Table 1 – Department of Planning and Infrastructure

Table 2 – City of Sydney

DRAWING TITLE  
 PROPOSED CLEARANCES TO RMS  
 ROADWAY STRUCTURES

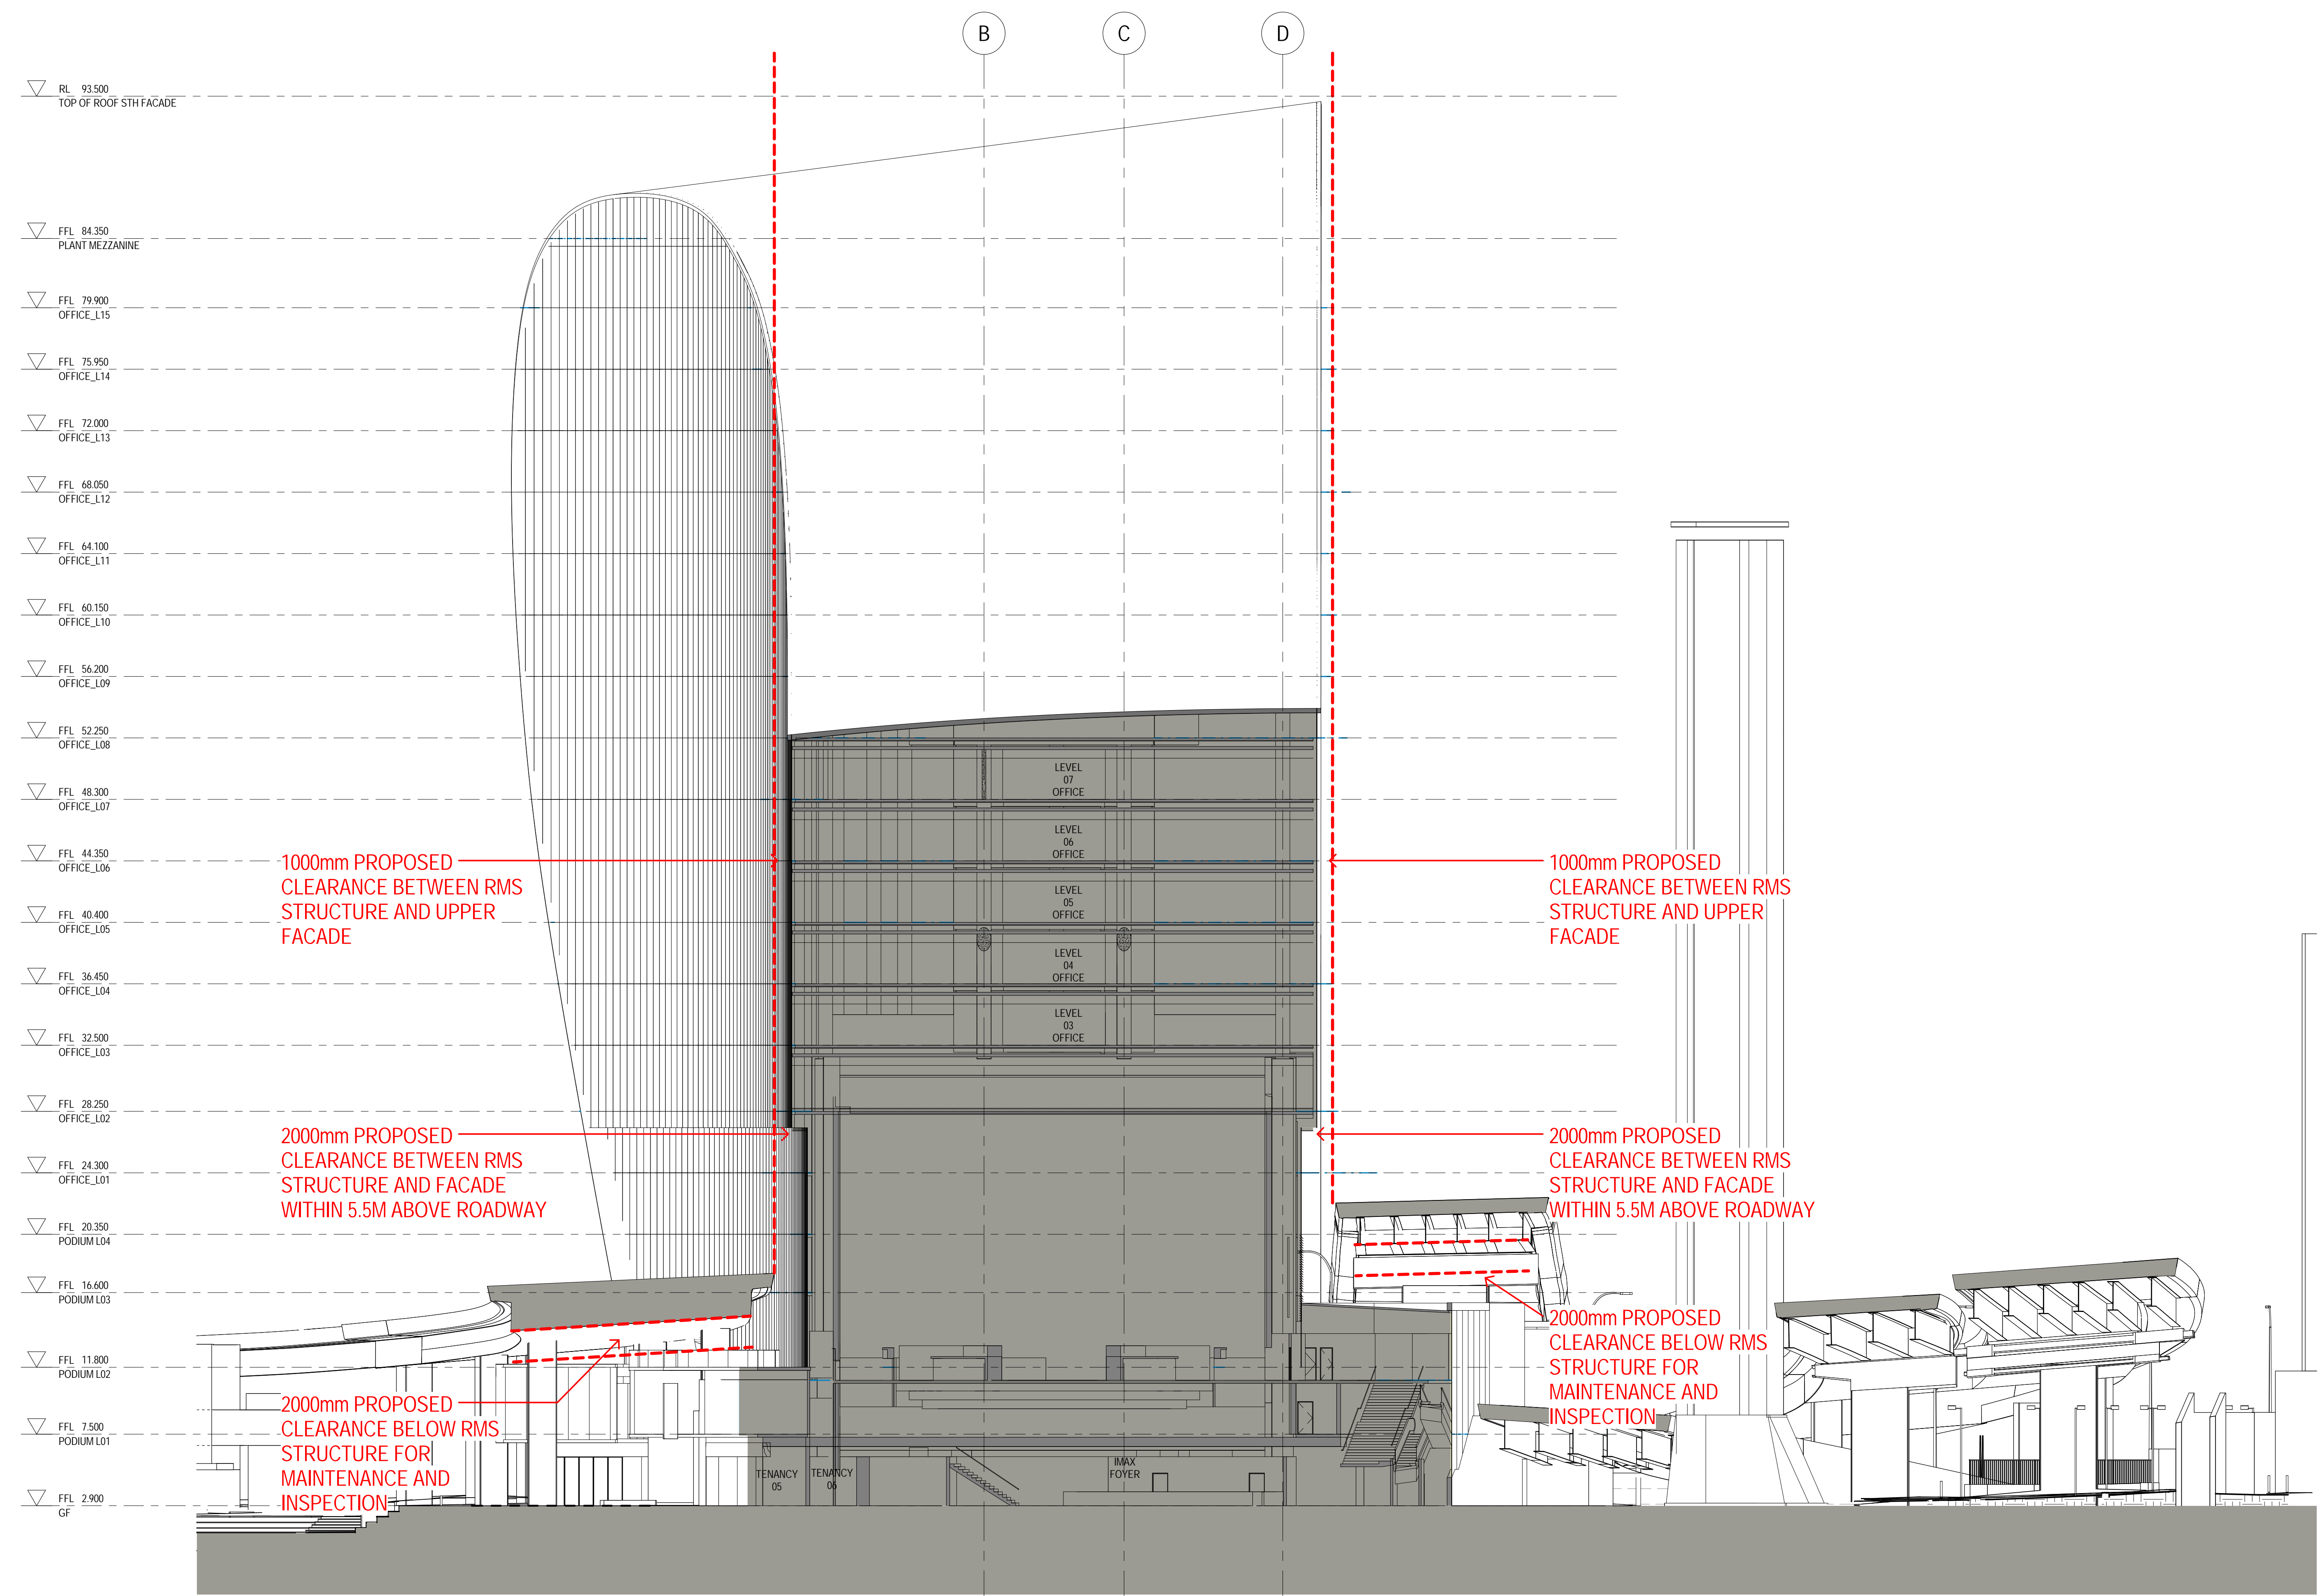
Additional information is to be submitted demonstrating consistency with RMS requirements for setbacks and clearance requirements to the Western Distributor.	Refer Section 2.7.2 of Response to Submissions.
	Further assessment of the loading, bicycle and motorbike spaces within the proposal is to be undertaken to address the City of Sydney Council submission.	Refer Section 2.7.2 of Response to Submissions.
	Additional traffic impact analysis of the proposal upon key intersections with the locality is to be undertaken to address the City of Sydney Council submission.	Refer Section 2.7.2 of Response to Submissions.
	Assessment of the proposal against the provisions of the draft Sydney City Centre Access Strategy.	The draft Sydney City Centre Access Strategy highlights a number of major changes which could be implemented to achieve three key outcomes in the Sydney City Centre, including: 1) Reduced congestion 2) Provision for future growth 3) Improved customer experience. With an overarching aim to shift a greater proportion of people using Public Transport to access key locations around the Sydney City. This proposal complements the outcomes of the Strategy, with a suitable car parking, bicycle parking and end-of-trip facilities and adequate links to public transport. In addition, the proposal is not expected to
